Application No: A/25/21/A
Site Address: Land South of Water Lane Angmering
Description of works: Erection of 5 No. non-illuminated Banner flags and 10 No. non-illuminated Totem signs.

Thank you for your internet representation made on 11th March 2021 which has been recorded as an objection with the comments as follows:

Barratt Static Banner
Barratt Logo
Flags - 600mm x 2200mm

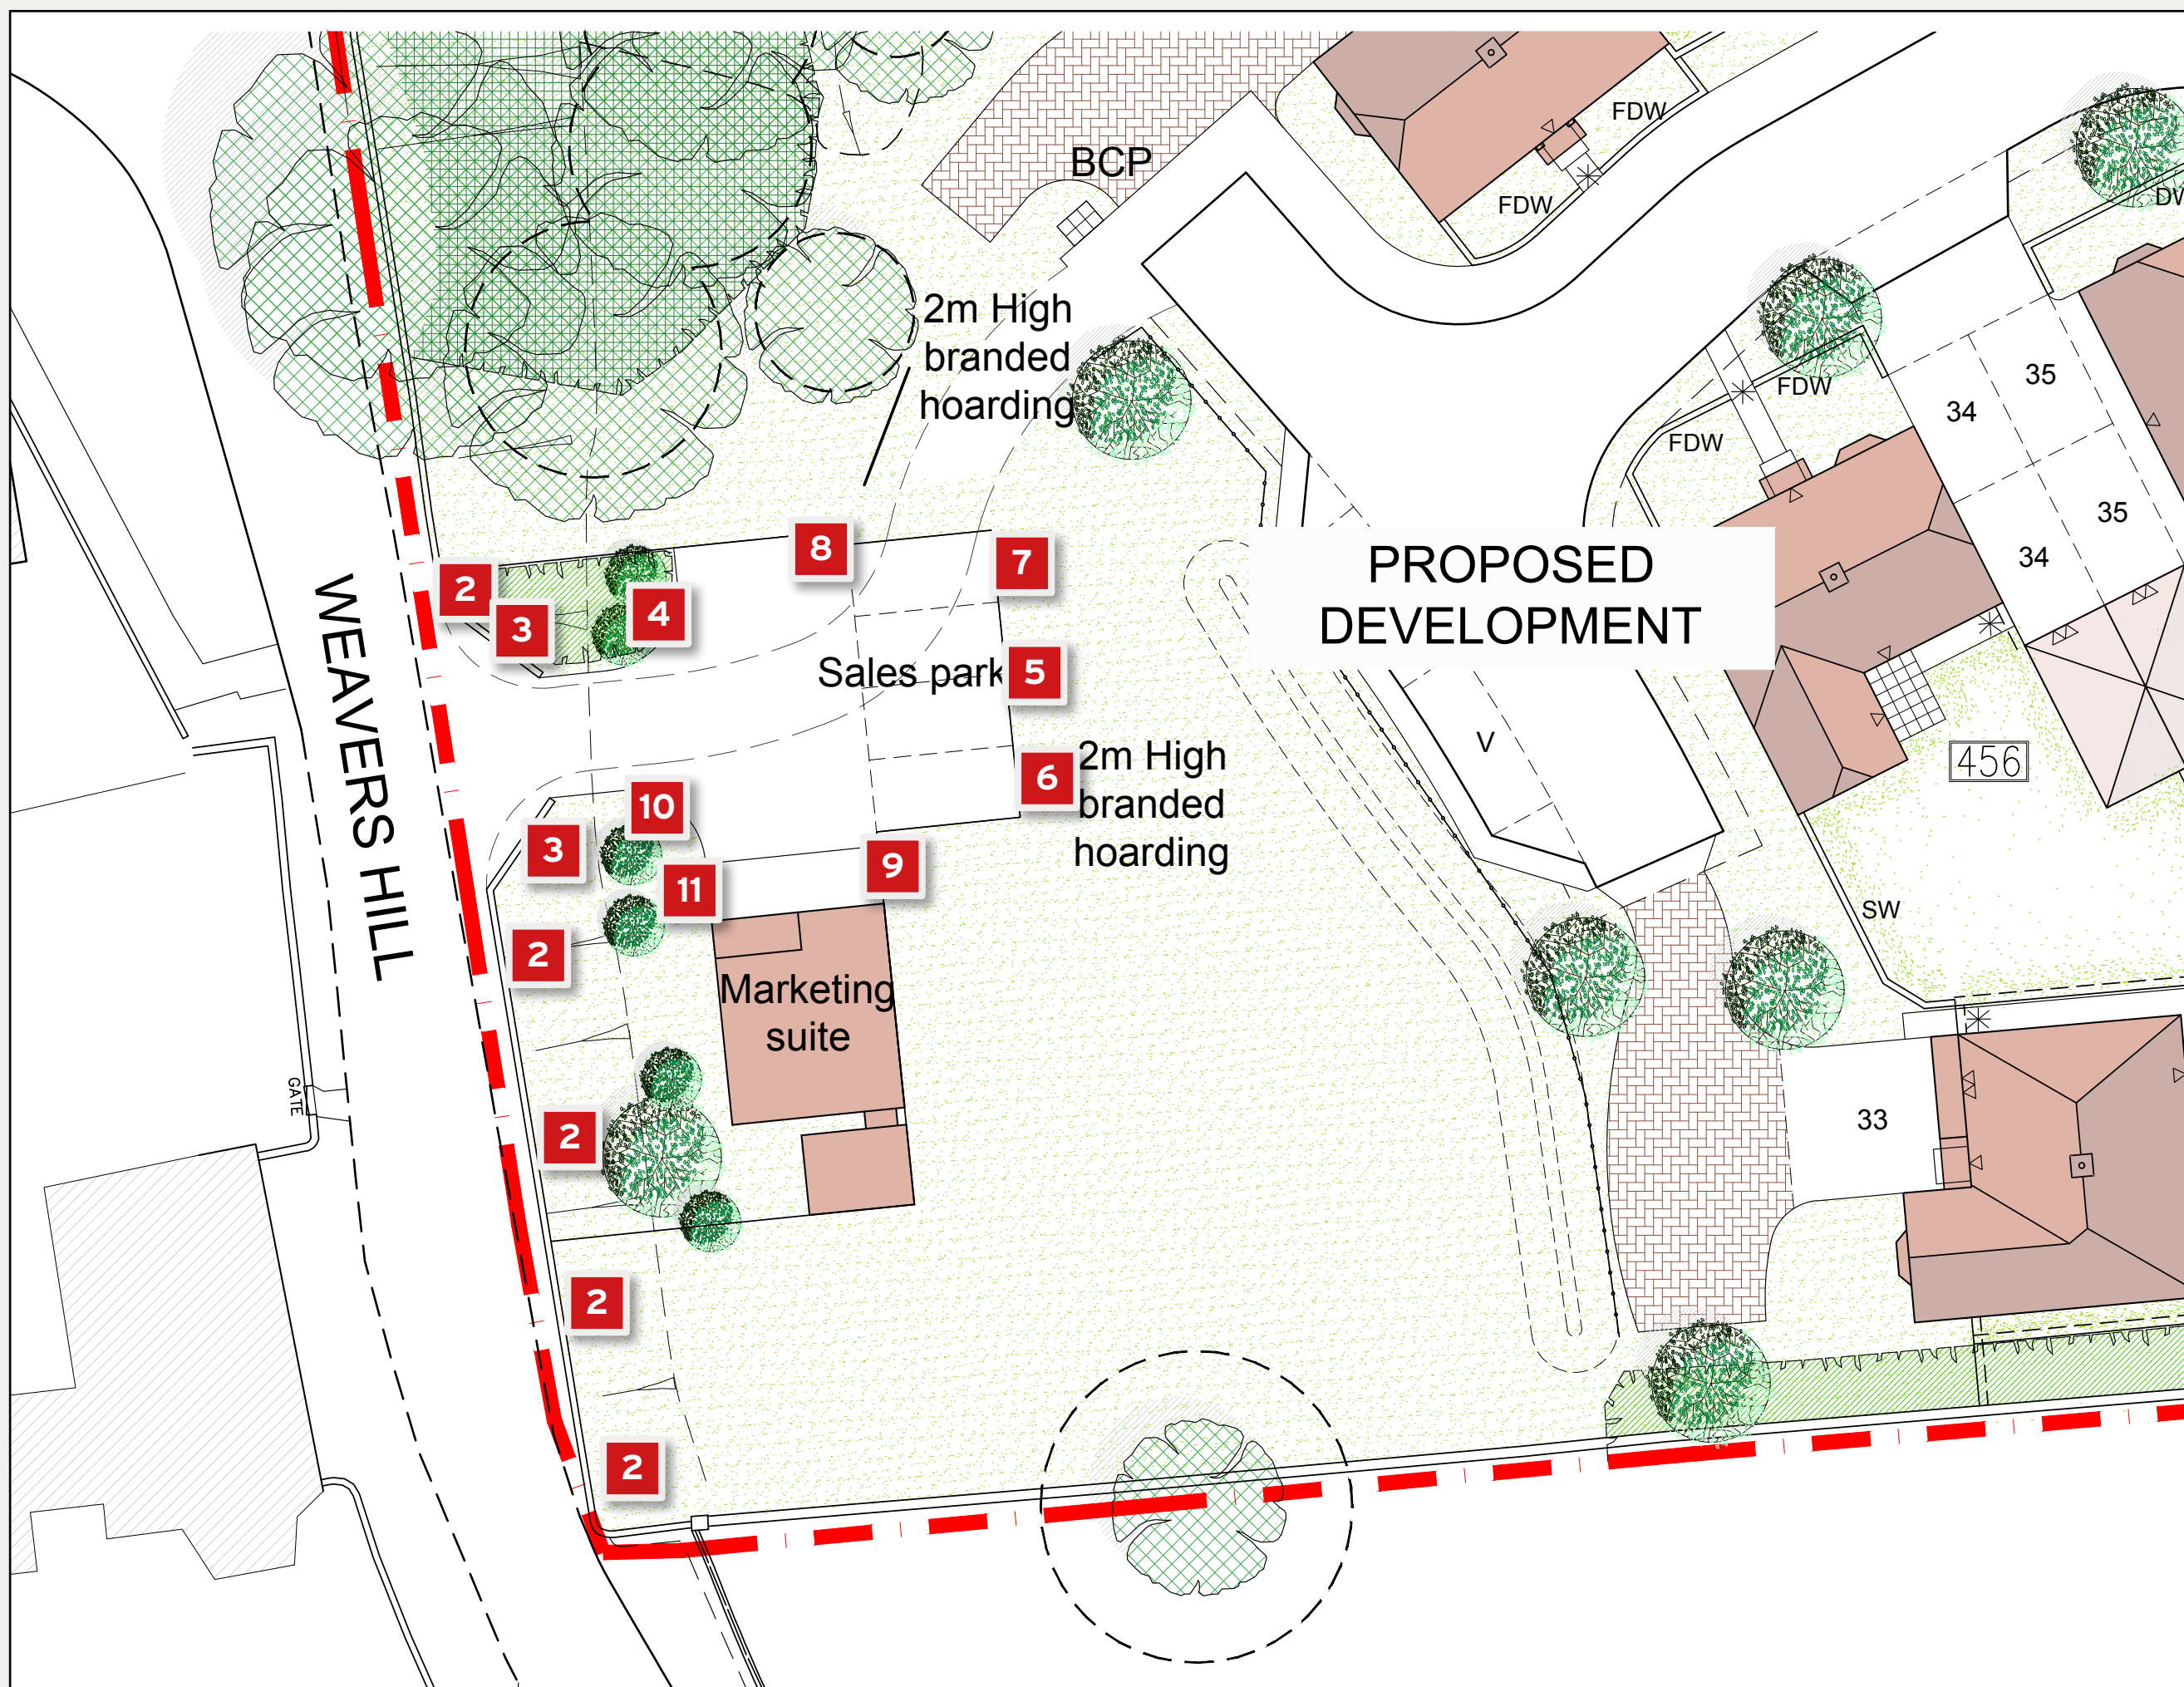
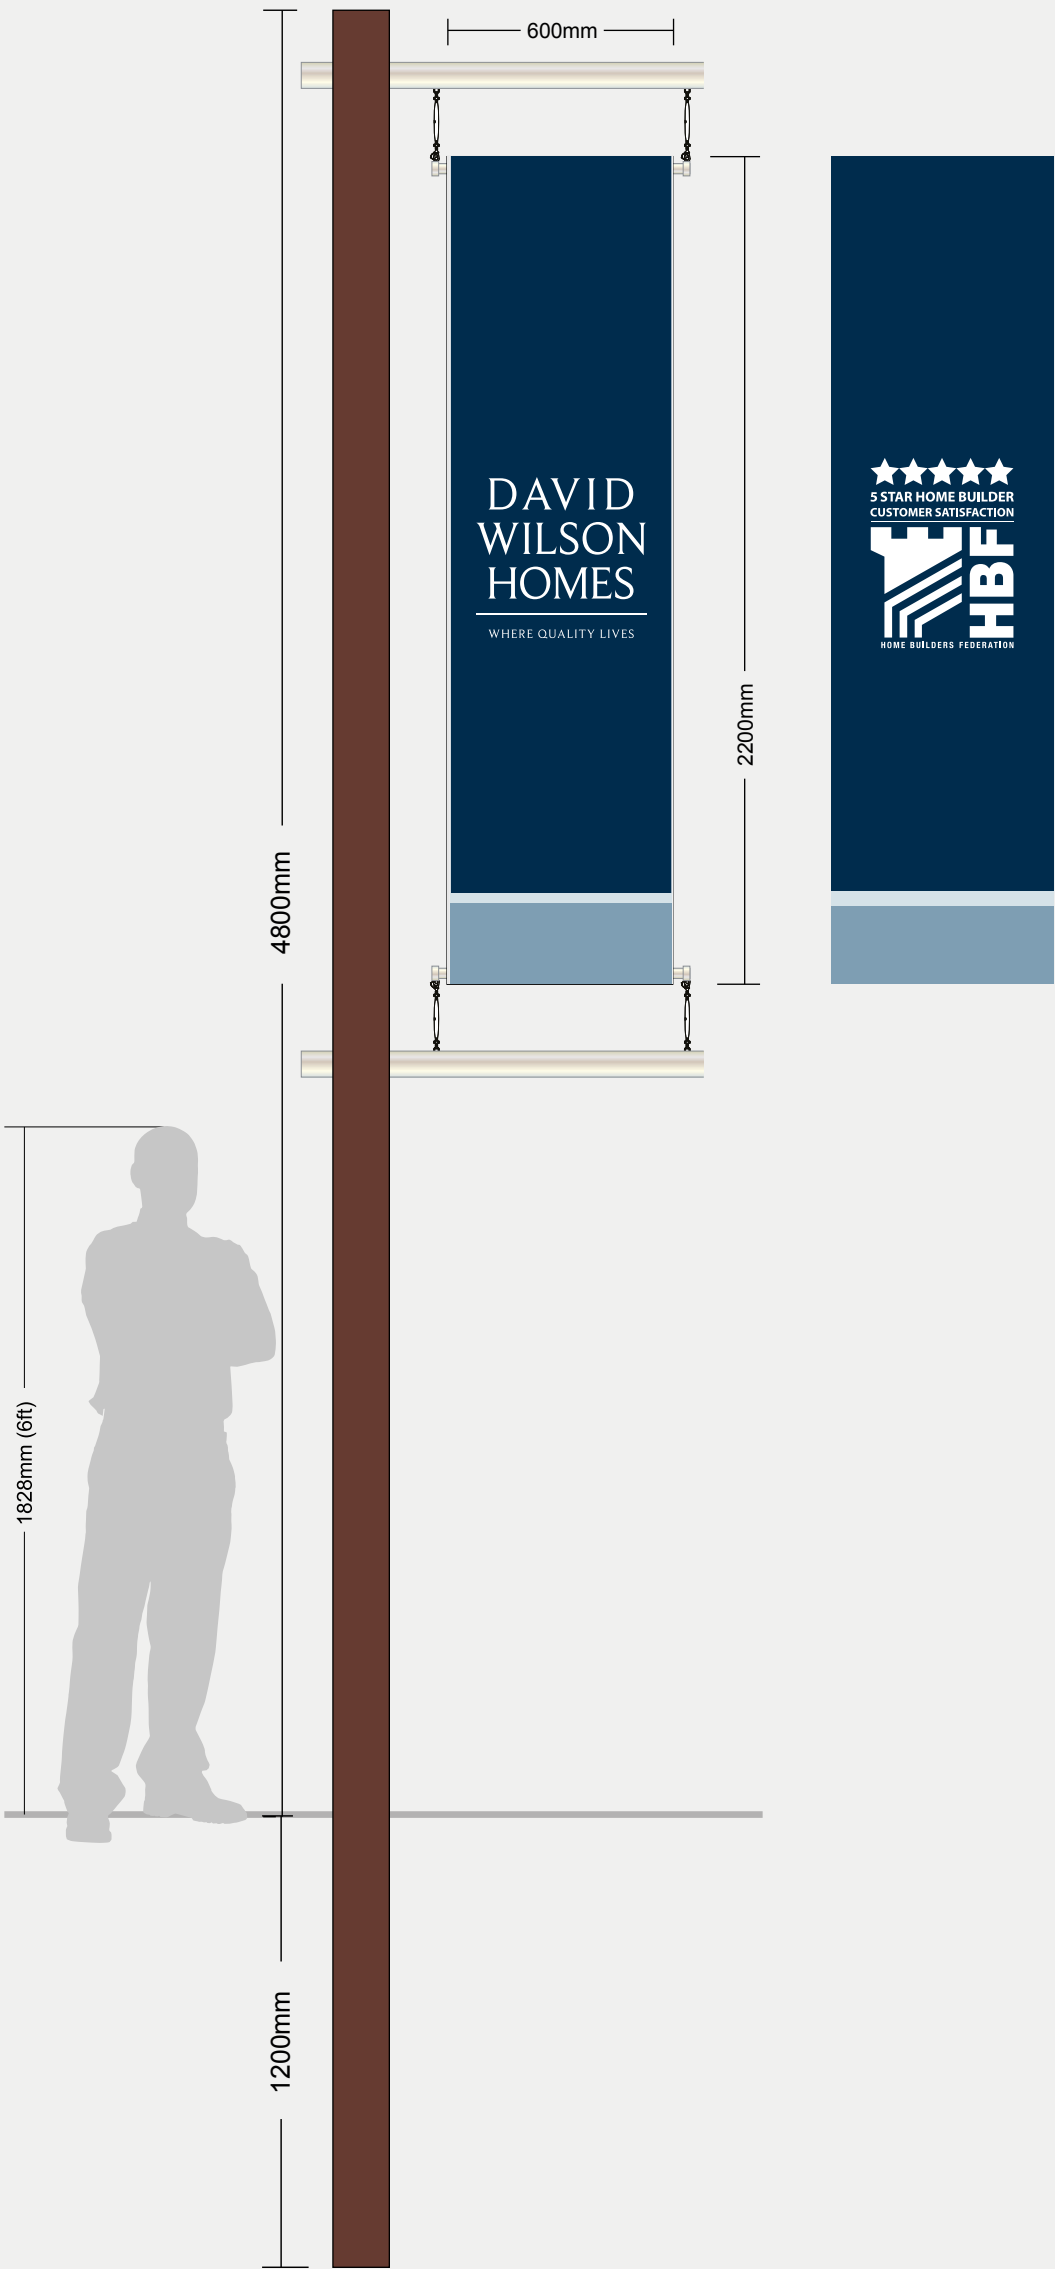
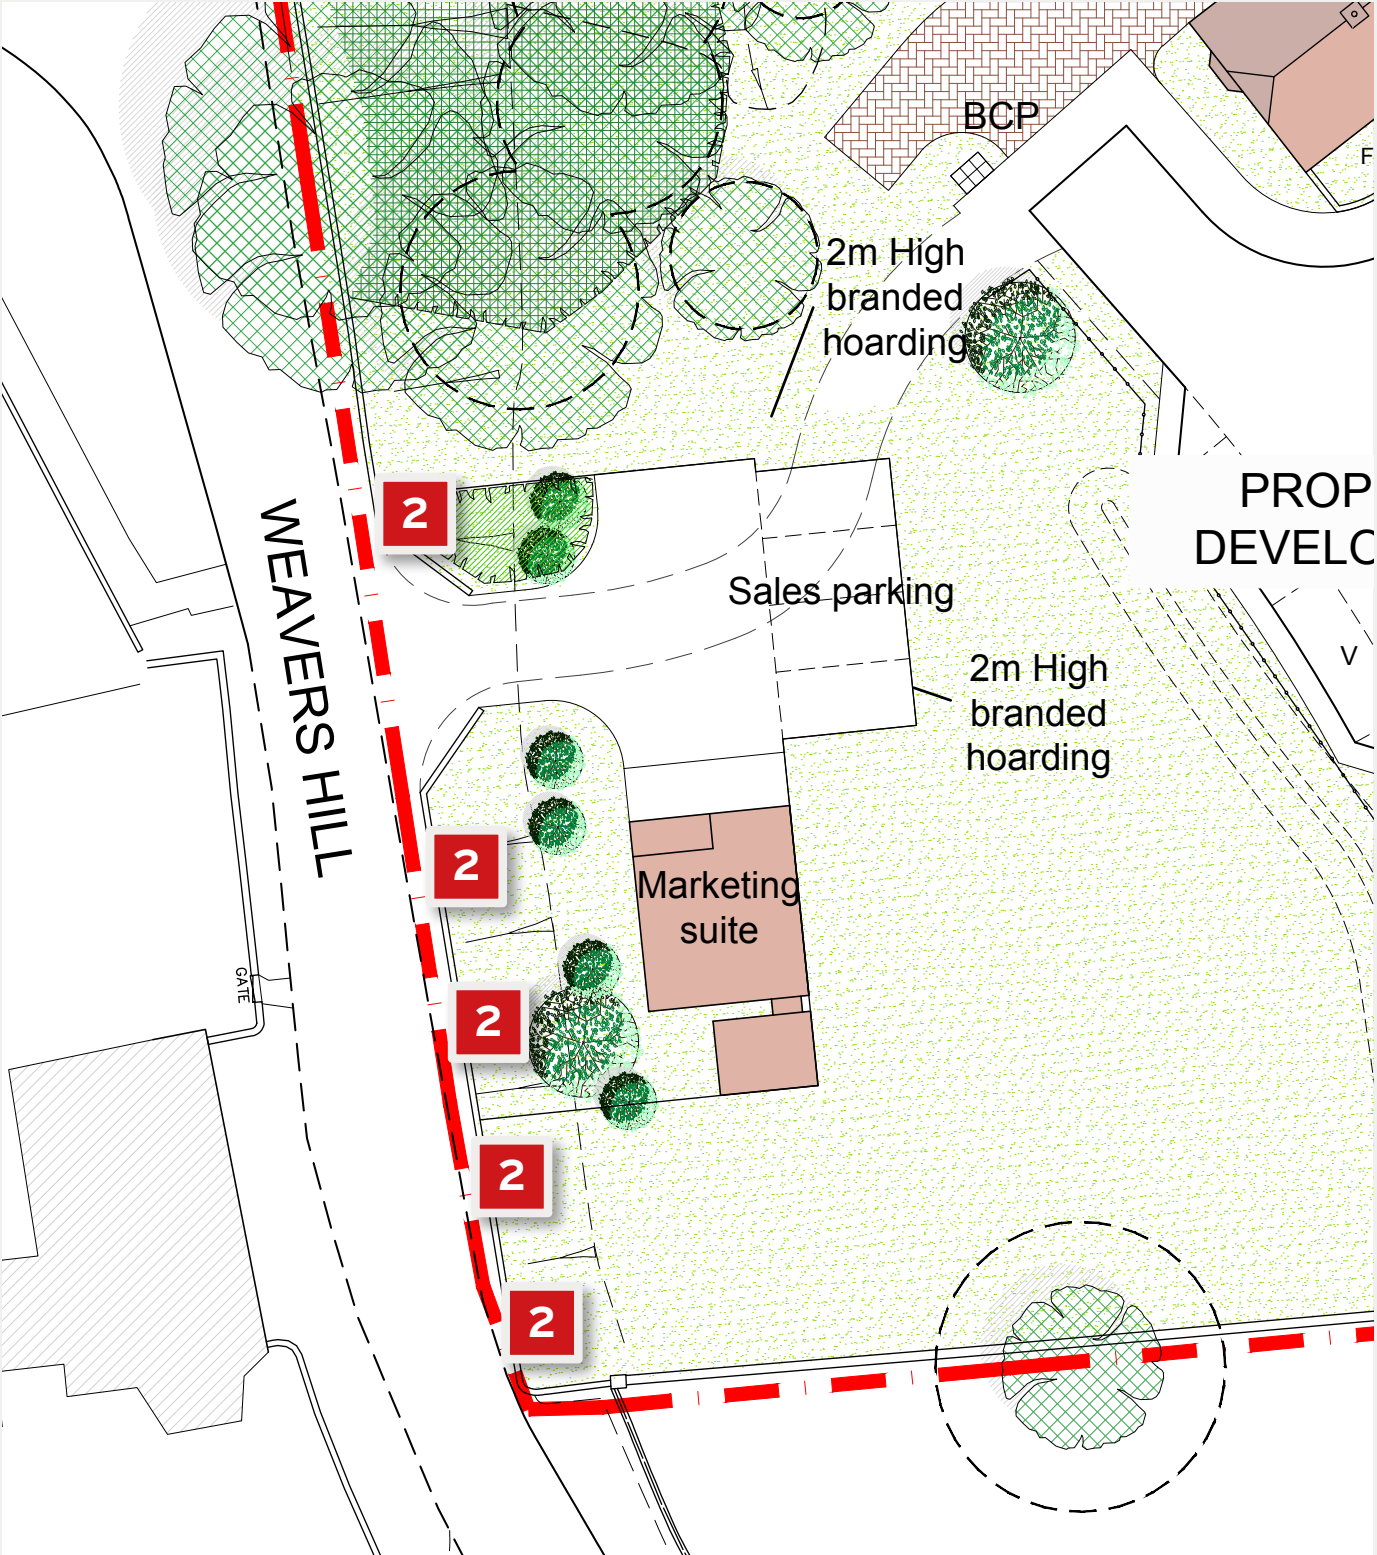
1. In accordance with NDP checklist this application contravenes EH1 as it will have a detrimental visual effect on the Angmering Conservation Area which it adjoins.
2. Road Traffic Safety. The use of flags and advertising boards could constitute a distraction to drivers on a very narrow lane that has shared use with pedestrians, vehicles and public transport. The proposed site is also immediately to the north blind corner.
3. Noise pollution. The siting of the flags may cause a noise disturbance to two residential properties, both within the Angmering Conservation Area. One directly across from the proposed site and a second alongside the site to the south
